5ft2 STUDIO ARCHITECTS, LLC

11/14/2023

John Janusson and Betty Yee
7218 78th Avenue Southeast
Mercer Island, WA 98040
Reference: SUB22-005 – Public Comment Response

The following is in response to the email to Molly McGuire, Planner at the City of Mercer Island Community Planning and Development, dated August 24, 2023.

# PRELIMINARY SITE PLAN

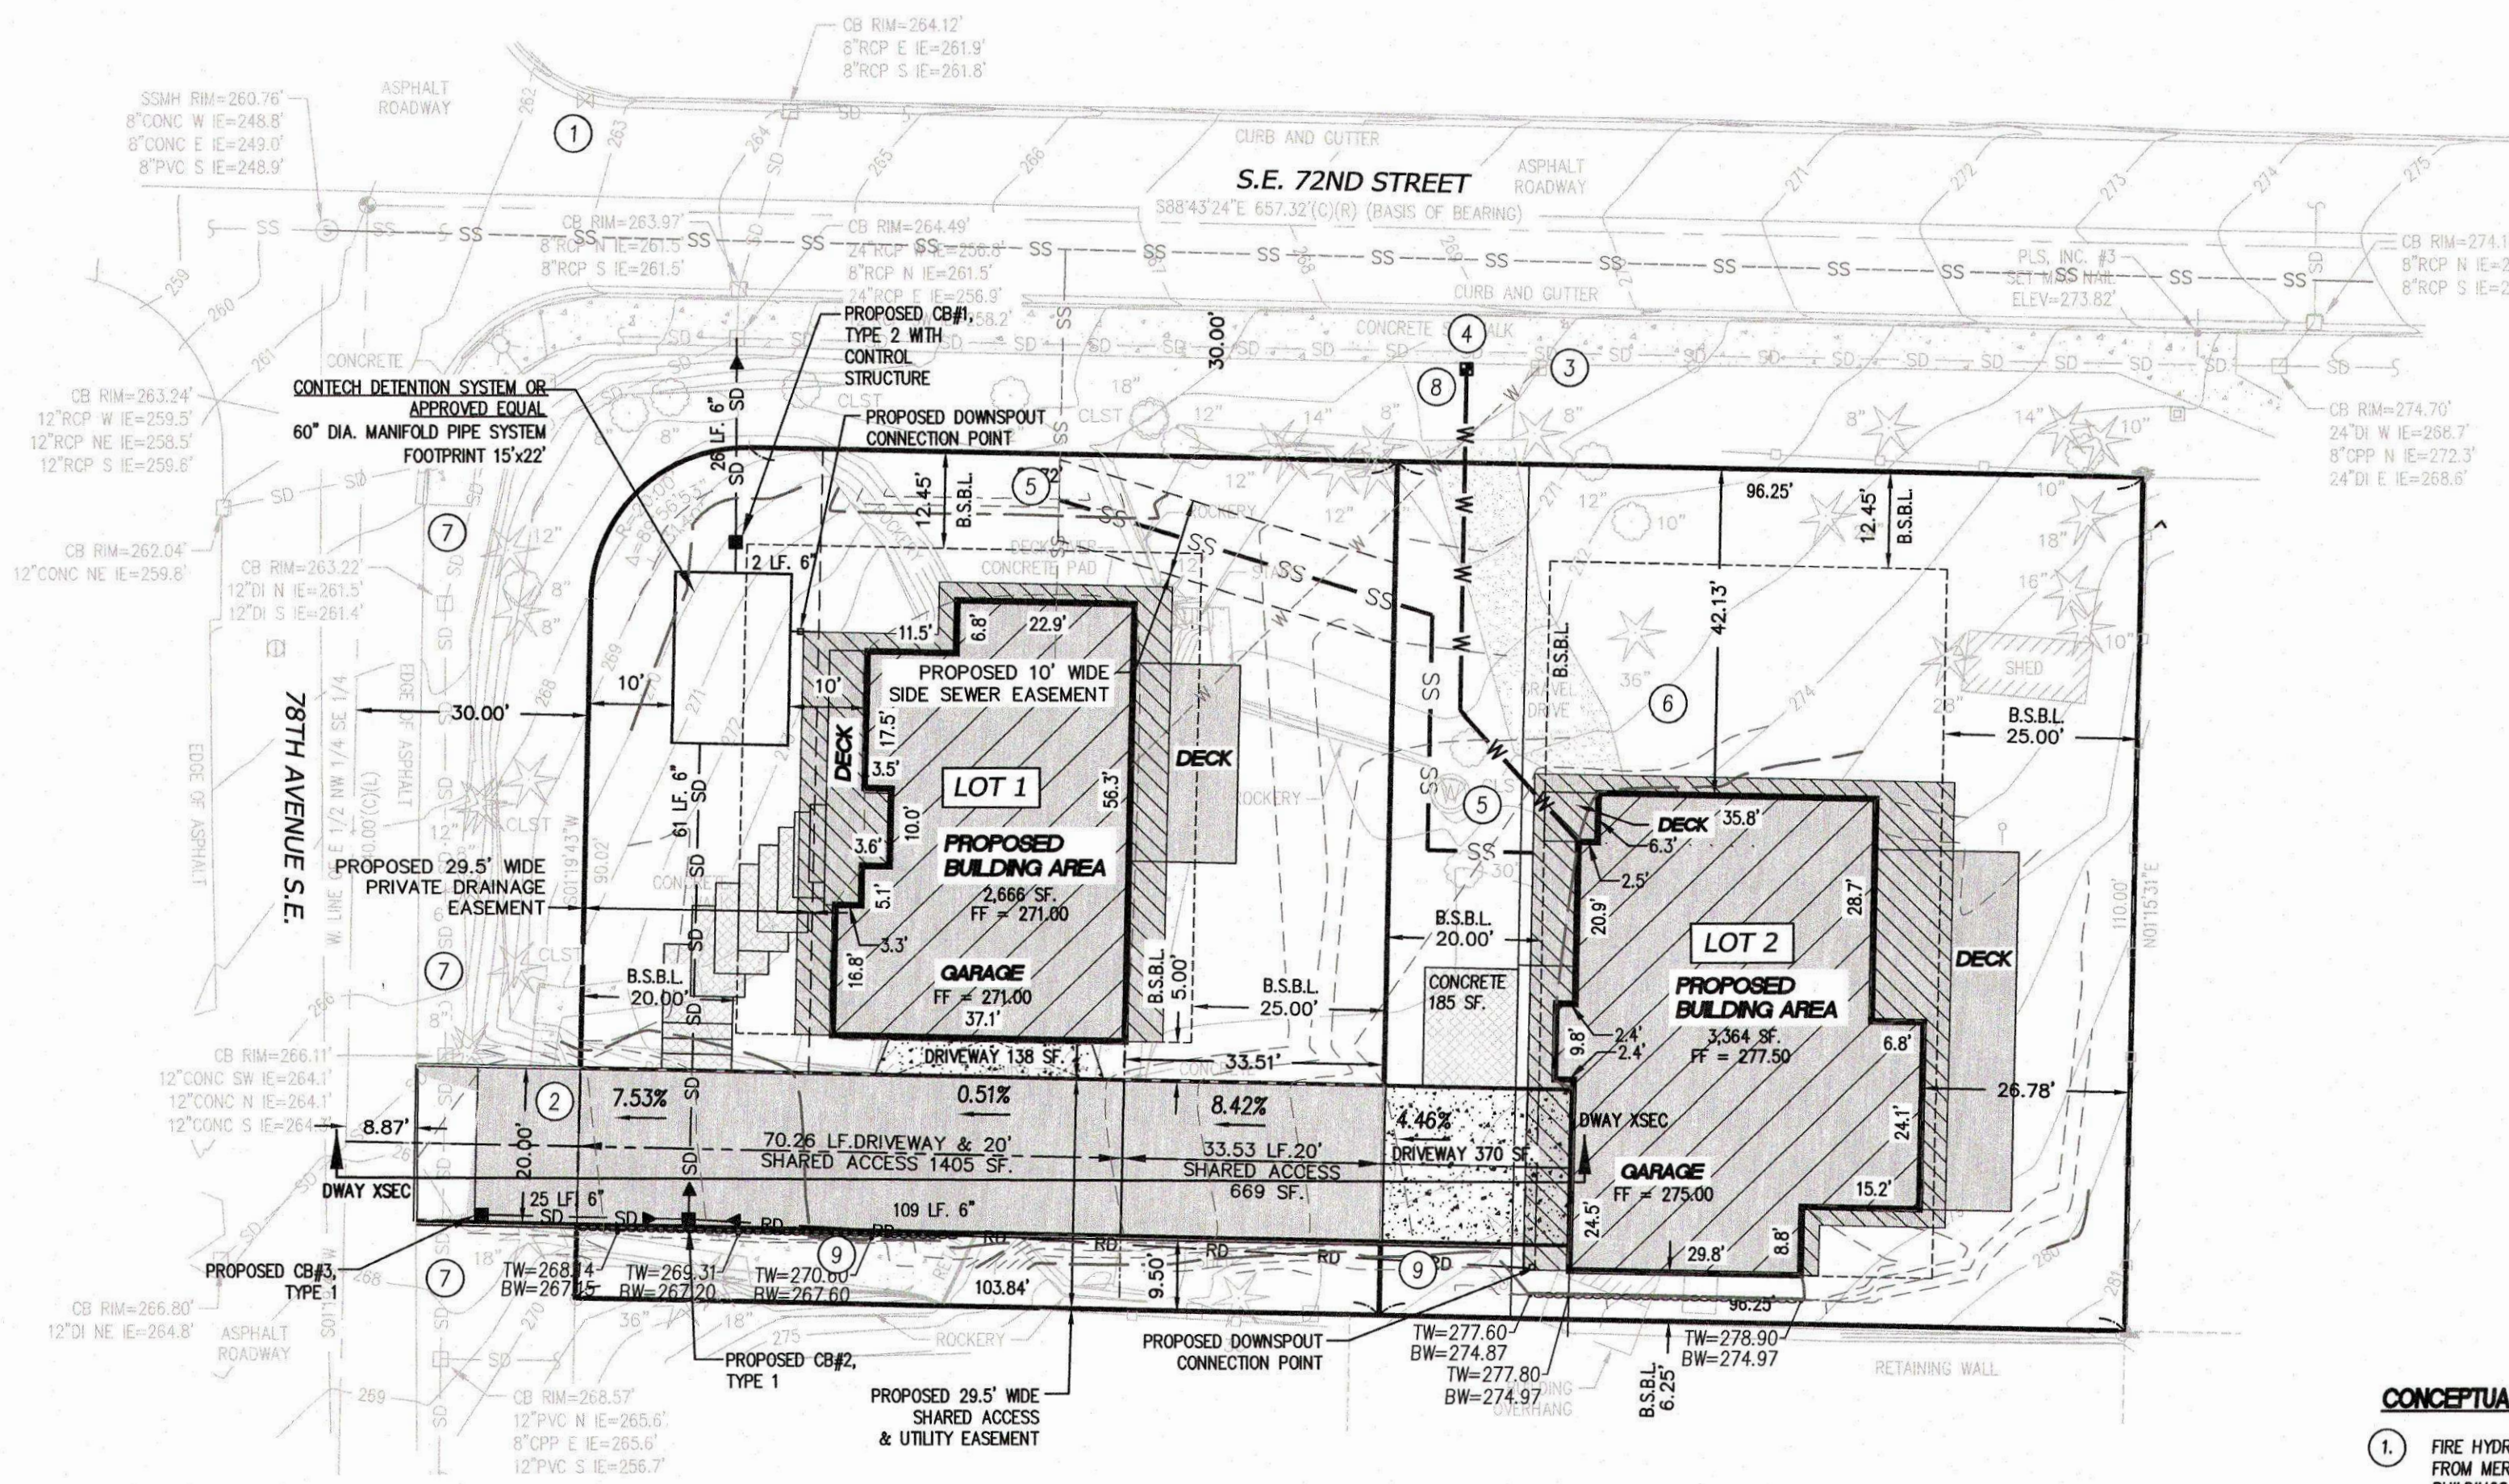
1) Per the plan the clearance from the building and our property line is 6.25 feet, and there are statements in the tree retention plans that state the lot 2 house will be moved even closer to our property for tree clearance reasons. What is the minimum clearance allowed by code?

2) The drawing shows a "retaining wall" between the lot 2 house and our property line. Our property line features a retaining wall of our own. In short - this plan states the in the 6.25 feet between our property

line/retaining wall and the new house there will be another retaining wall.

My respectful request to see more details on on the site plan as I feel it is currently not compliant or feasible without changing the floorplan of the buildings.

I'm copying our previous concerns here Sept 13, 2022 - In reviewing the Preliminary Lot Plan, the garage of the home on Lot B is planned close to our property. We request that the Lot B residence setback from the South property line be increased by 10 feet over and above the minimums defined by code. This would allow a natural privacy barrier such as arborvitae to be planted on the south side of Lot B and grow to a significant height. We would not be able to accommodate a natural barrier or fence on our property without removing our preexisting fruit trees.

As noted in the Pre-Application Meeting (PRE21-052), no projections, including eaves, are permitted in the minimum side yard setback from interior lot lines, and the garage should be designed accordingly.

- 1) The total side yard depth for Lots A and B are 18.7 feet based on the lot widths of 110 feet (i.e. 17% of the lot width). The minimum individual side yard is 6.2 feet (i.e. 33% of the total side yard depth). Note that variable side yard setback requirements may increase the minimum individual side yard requirements based on building height adjacent to the side yards. The greater of the side yard setbacks applies. See MICC 19.02.020.C.1.c.
- 2) If the building height is less than 15 feet along the side yard, no variable side yard setback requirement applies. The side yards would be determined by lot width: 18.7 feet total side yard depth and minimum individual side yard depth of 6.2 feet.

The proposed building height along the side yard intent to stay below 15 feet, hence no variable side yard setback requirement applies, the minimum individual side yard depth is 6.2 feet. This will be respectfully adhered to during building permit. In addition, it will not be approved by the city if compliance is not met.

Response: Please refer to response letter from Apex Engineering.

Response: Per email by Planner, Andrew Leon of the city dated September 15, 2022, 11:45 AM. Andrew clarify that As a part of review of the subdivision and building permits for future houses, the city will be ensuring that building pad and setback requirements are being met.

Response: In the context of this development project, the sole access point to the site is limited to 78th Ave SE, with a crucial stipulation that access must remain within 150 feet to avoid the impracticality of requiring a fire engine turnaround. As a result, the garage design is tailored to meet the minimum setback requirements. Furthermore, a strong emphasis is placed on preserving the trees along the northern side of the property to minimize environmental impact, this comply with the city requirement of conserving exceptional trees. To foster neighborly relations, the decision has been made to construct the garage as a single-story building.

Response: There will be no projections, including eaves, are permitted in the minimum side yard setback from interior lot lines, and the garage current footprint is reflecting this and it will be designed accordingly.
